**RE: Suazo Residence
6511 Petirrojo Rd. NW
Request for permanent C.O. – Accepted
Engineers Stamp Date 4/16/14 (J13D096)
Certification Dated 11/10/16**

**RE: Suazo Residence
Lot 8, Block 10 Volcano Cliffs Unit 22
Grading and Drainage Plan
Engineers Stamp Date 9/29/16 (D10D003P8)**

**RE: Suazo Residence Lot 8 Block 10 Unit 22 Volcano Cliffs
6511 Petirrojo NW
Grading and Drainage Plan
Engineers Stamp Date 1/15/16 (D10D0003P8)**

ENGINEER'S SEAL	LOT 8, BLOCK 10, UNIT 18 VOLCANO CLIFFS SUBDIVISION	DRAWN BY JDG
	GRADING AND DRAINAGE PLAN	DATE 01-14-2015
		SHEET # 1 OF 1
1/15/16		JOB #
DAVID SOULE P.E. #14522	1606 CENTRAL AVENUE SE SUITE 201 ALBUQUERQUE, NM 87106 (505) 872-0999

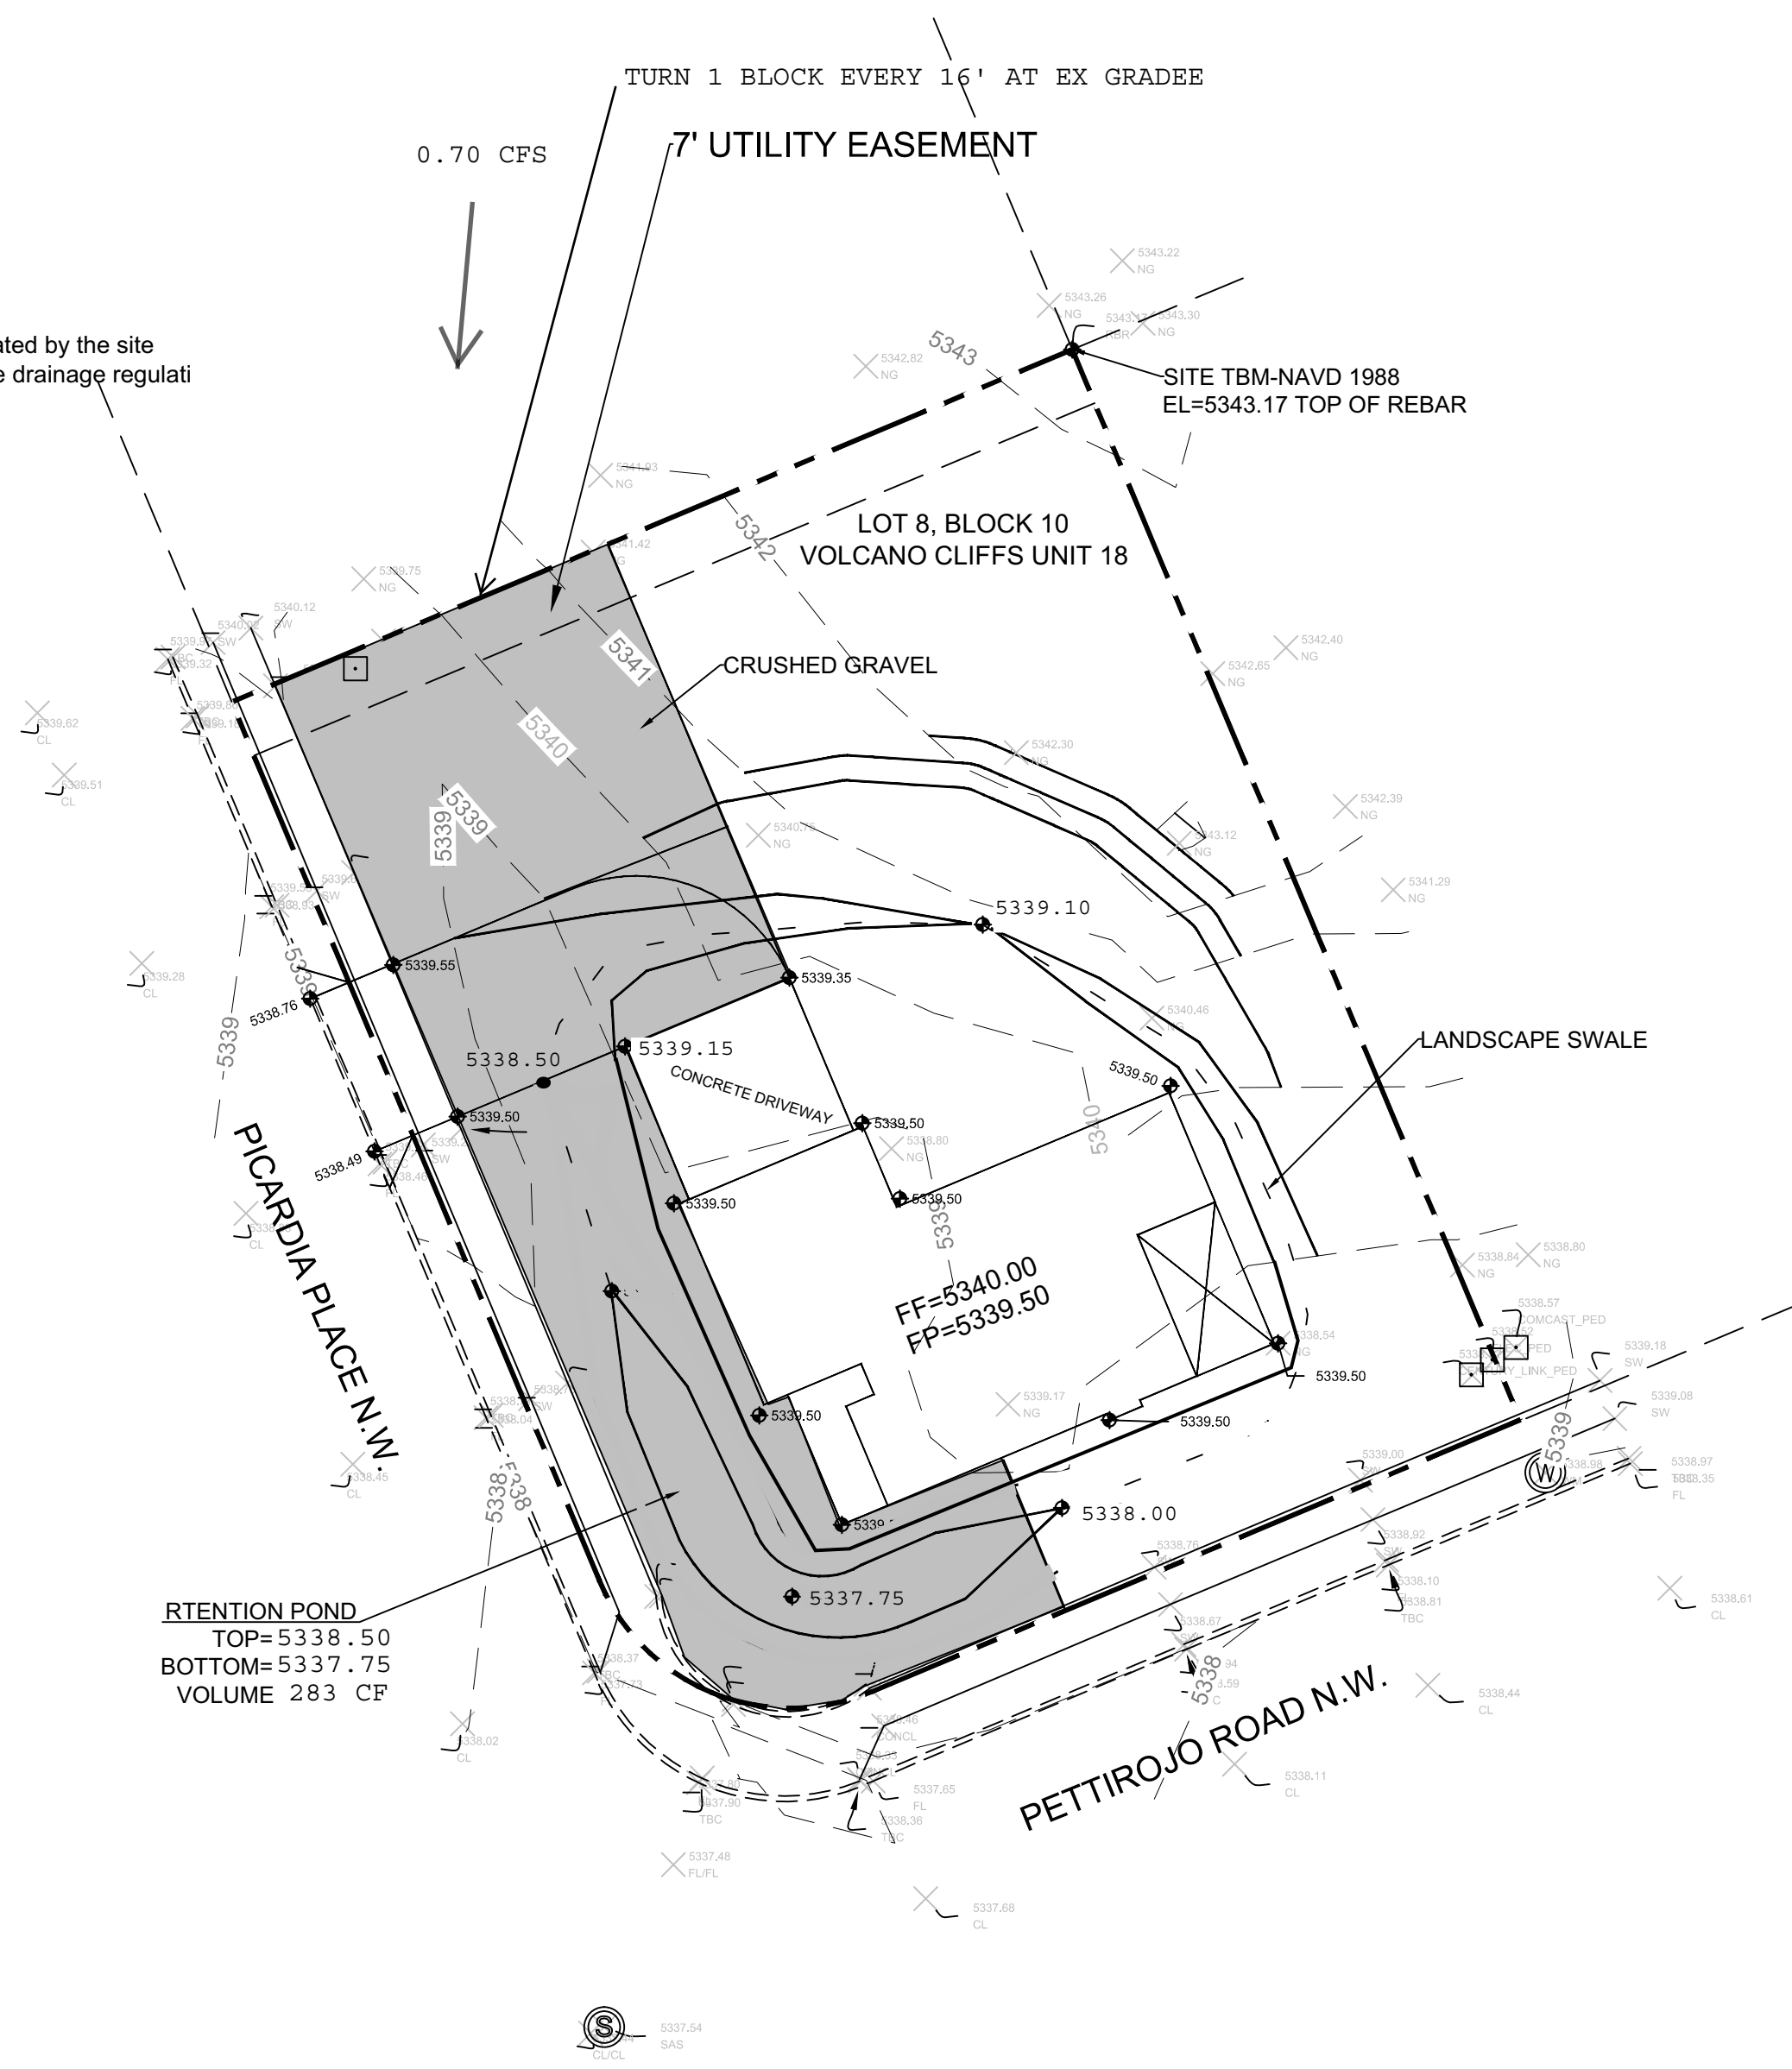
Based upon the information provided in your submittal received 1/18/15, this plan cannot be approved for Grading Permit and Building Permit until the following comments are addressed.

- Provide turn blocks in the east and west rear yard walls to allow flows to pass through and into the double sidewalk culvert in Picardia Place.

ADDED NOTE TO TURN BLOCK
